LAOIS COUNTY COUNCIL**MEMORANDUM**

FROM: SHANE BOOTH, A/EXECUTIVE ENGINEER, ROAD DESIGN OFFICE
TO: MICHAEL MALONE, SENIOR EXECUTIVE ENGINEER., ROADS DEPARTMENT
RE: PLANNING REFERENCE ACP-324015-25 MILFORD QUARRIES LTD
DATE: 19th JUNE 2026 FILE REF.: ACP-324015-25

Application under Section 37L of Further Development consisting of further quarry extraction etc at Clogrennane, Bilboa, County Laois.

D103 WHEELWASH DETAILS
SCALE:1:100

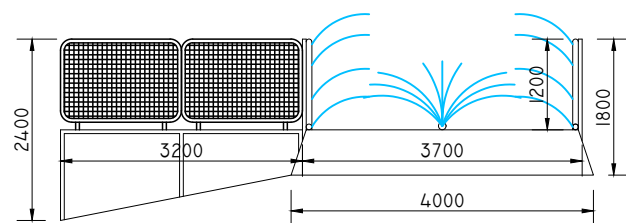
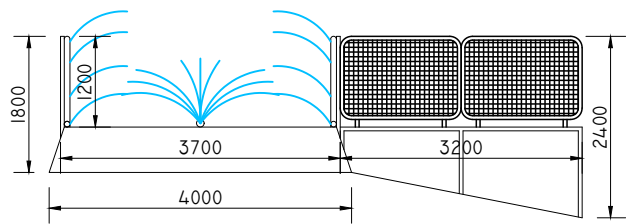
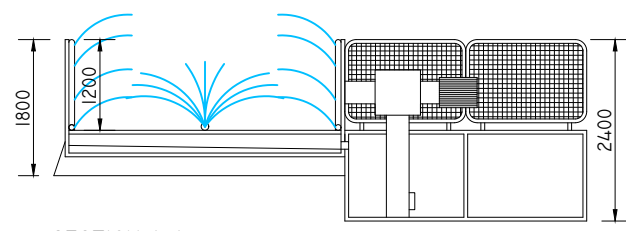
- All vehicles associated with the haulage of aggregates and other materials to the site shall enclose or securely sheeted to prevent future dust emissions. The developer shall provide and maintain a wheel cleaner(s) at the facility. The wheel cleaner shall be used by all operational vehicles leaving the facility as required to ensure that no mud or other debris is carried off-site. All water from the wheel cleaning area shall be directed via an interceptor to the trade effluent management system.

D107
TYPICAL ACCESS ROAD DETAIL
SCALE:1:100

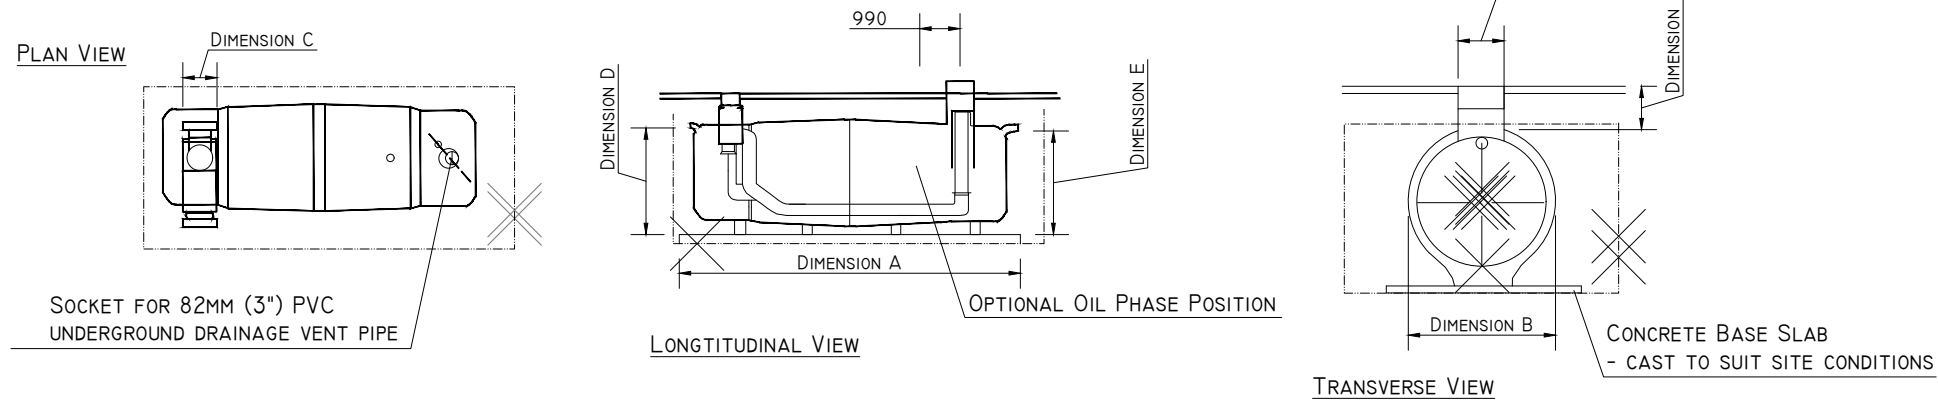
- The applicant shall ensure that no surface water run-off from the access driveway, disperses onto the existing public roadway.
- The applicant shall ensure all external lighting shall be cowled away from the public roadway.
